RE: Planning Application ref AW/299/24/HH at 8 Cherry Close, Aldwick

As a close neighbour to the property concerned in the above planning application, I wish to lodge my objection to the proposed plans.

PROPOSED ELEVATIONS

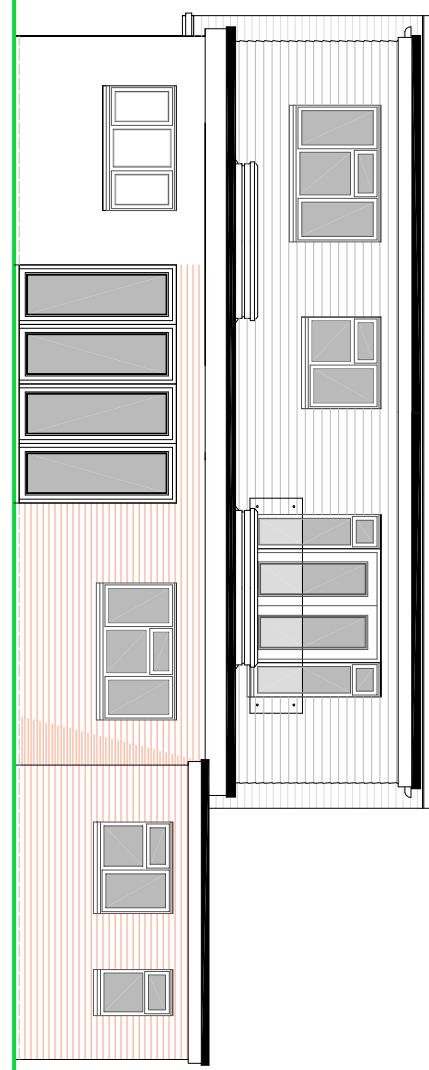
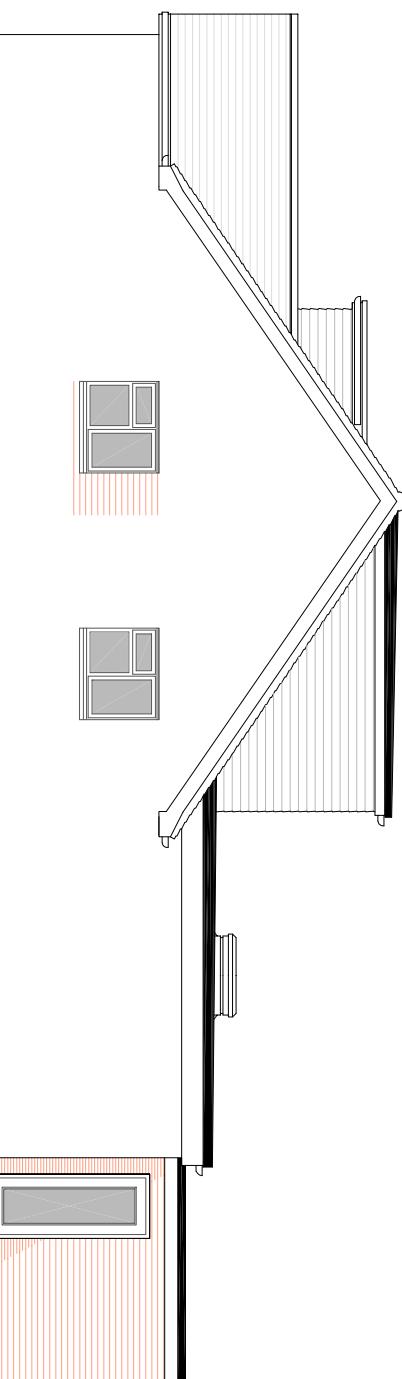
The proposed changes constitute a significant enlargement to the existing property, which is completely out of character within the neighbourhood of bungalows. From my property, which is located to the rear of the development site, the proposed changes will turn the rear elevation into a flat roofed house when viewed from my garden and property and is totally at odds with the neighbouring bungalows. This would result in the applicant having an overpowering view from the first-floor rear elevation of my single storey bungalow, including my front and rear gardens and the side window of my main bedroom. The full height double glass doors and Juliet balcony proposed are excessive and add to the overpowering nature of the proposals.
